Online Comment

Application H09-0306-26
Location Bakkavor Sluice Road Holbeach St Marks PE12 8HF
Proposal Erection of ground mounted solar array & associated works

Name Imogen Colenutt, Assistant Conservation Officer
Address Council Offices The Hub Mareham Road LN9 6PH

Date Submitted 24-04-26
For/Against Comments

Client		Bakkavor	
Project Title			
Solar Project			
Drawing Title			
Proposed Ground Layout - 3D and section			
Scale (@ A1)	Date		
1 : 100	Jan 2026		
Drawing No.	Drawn	REV	
368_07	MJF	A

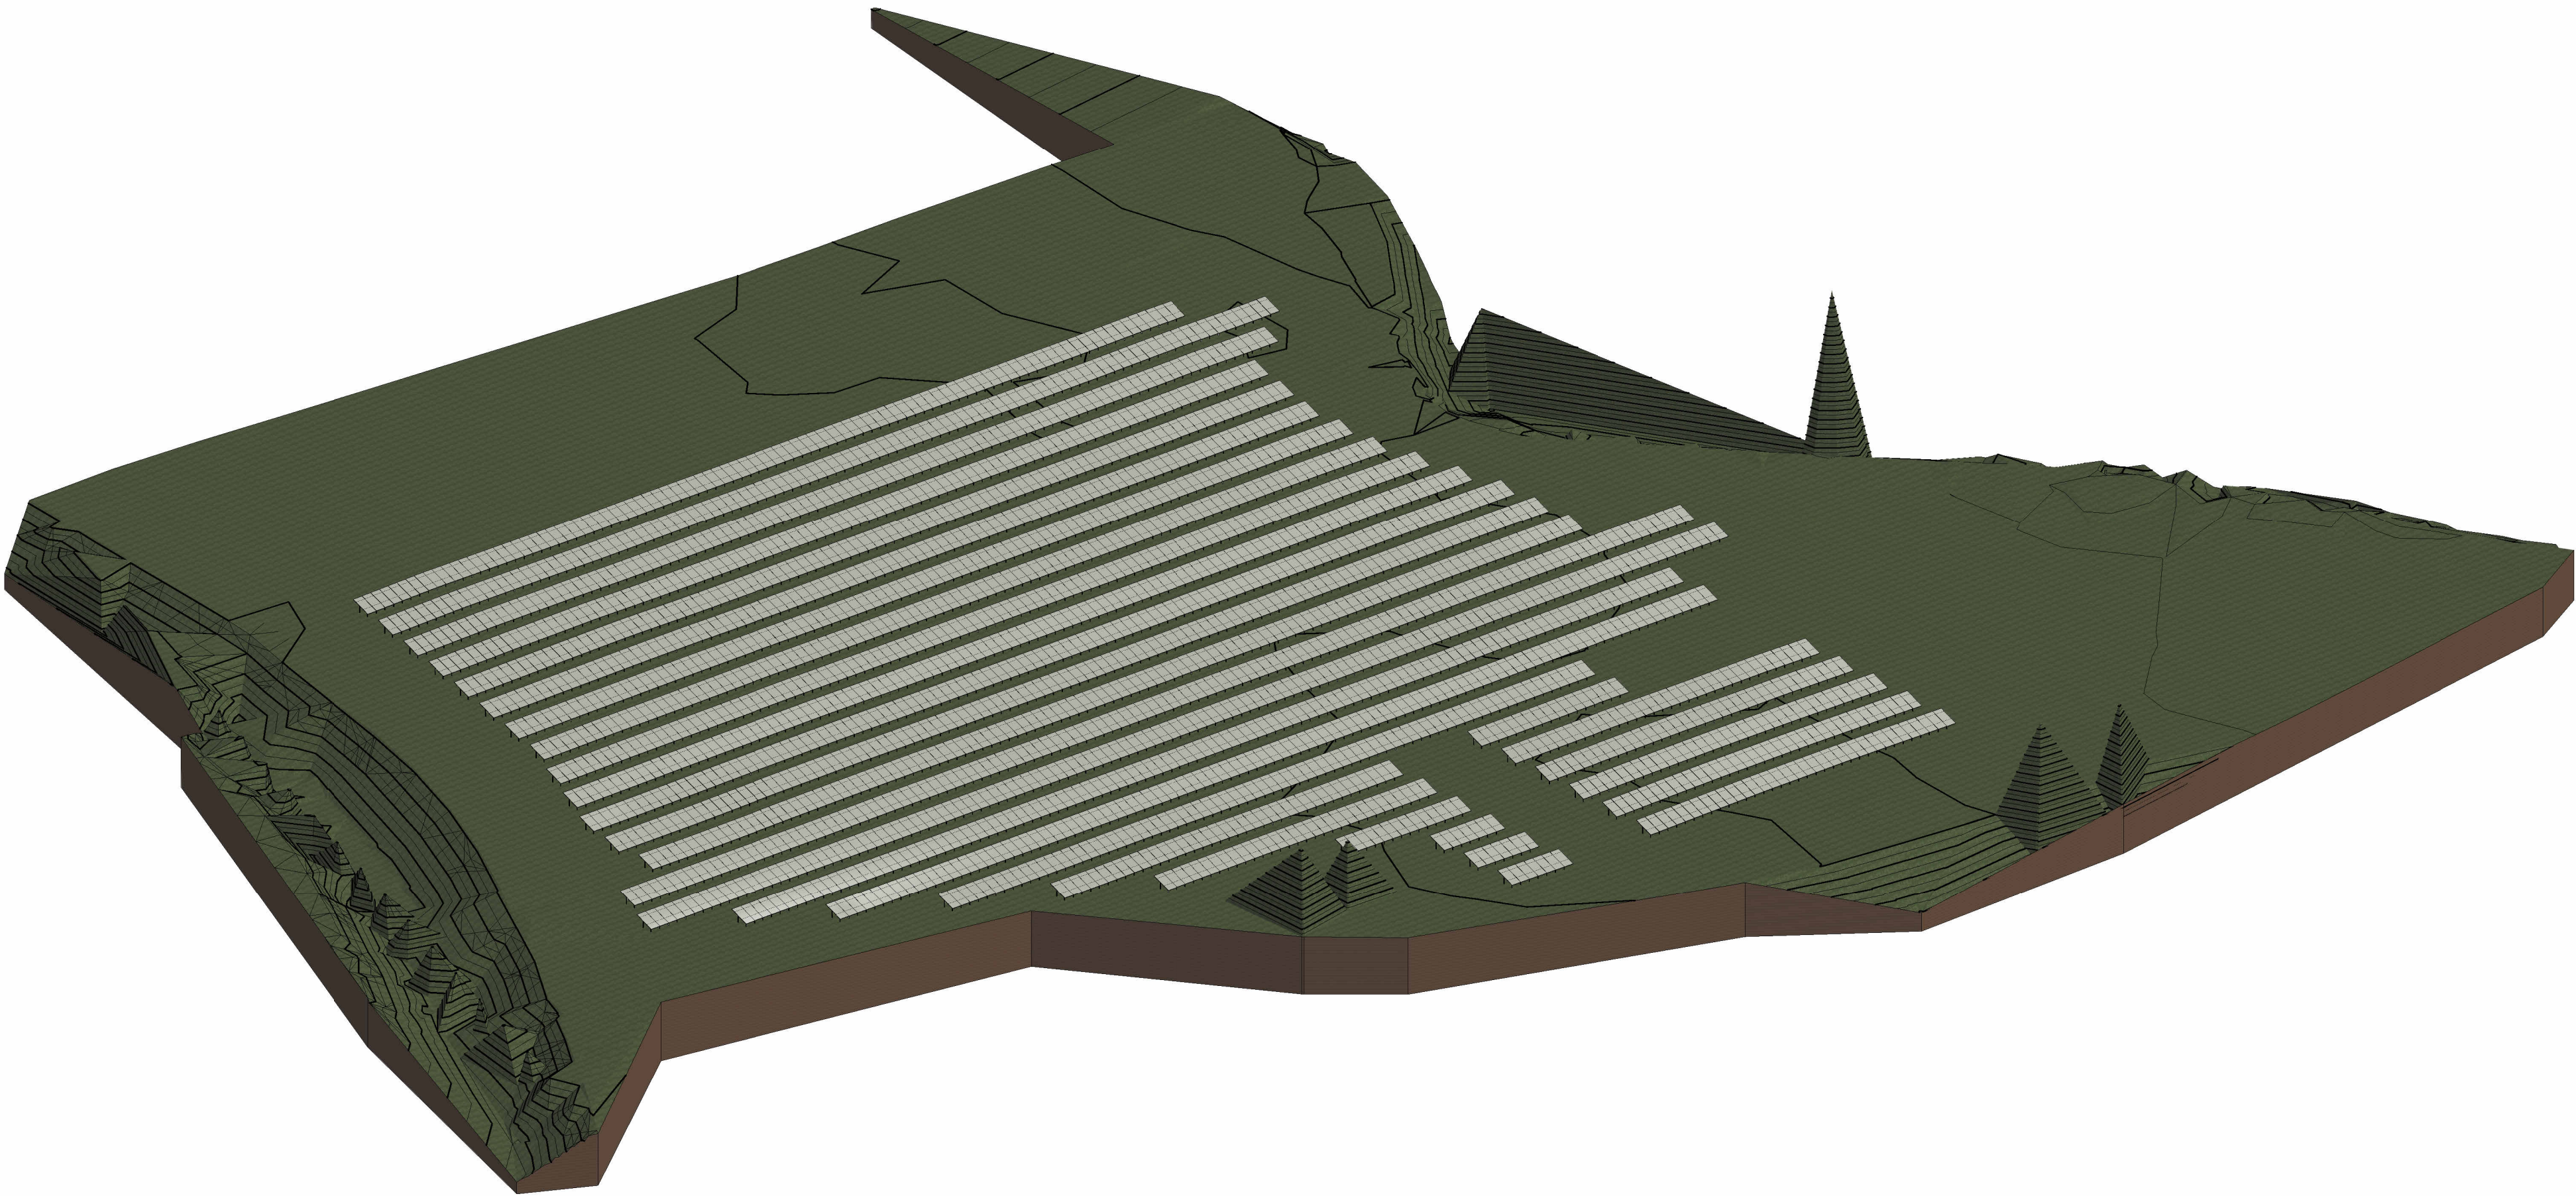
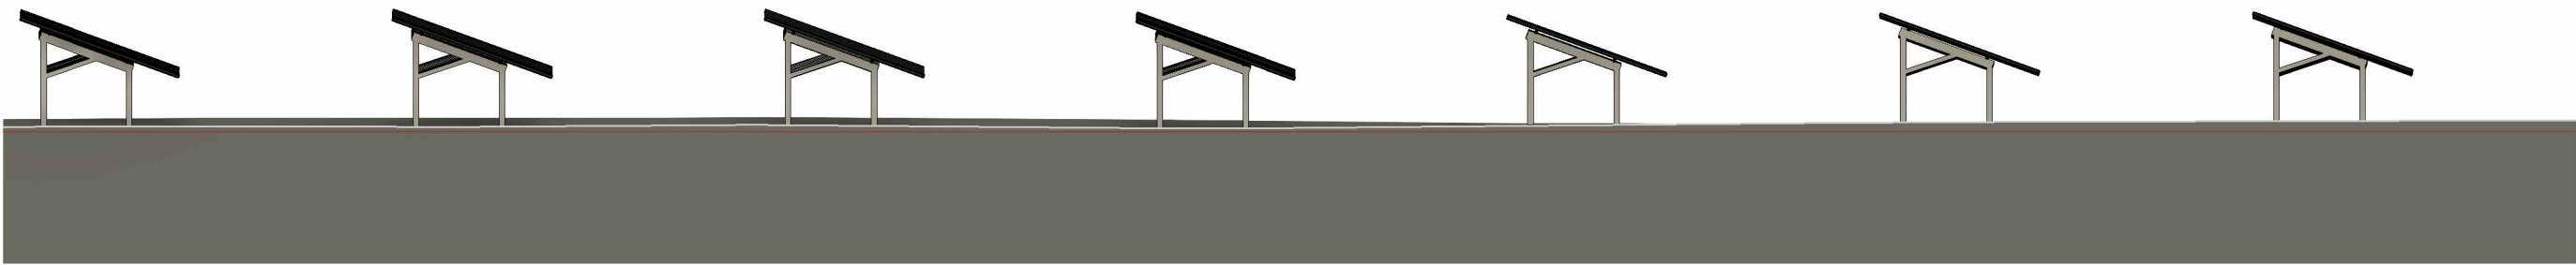
Therefore, confirmation is required of the total height of the solar panels at their highest point.

The submitted plans do not show any proposed boundary treatments, such as fencing or security camera posts. Please confirm whether any are proposed and, if so, provide details.

Additionally, clarification is required on whether the power generated would be stored within the neighbouring buildings or within a new structure.
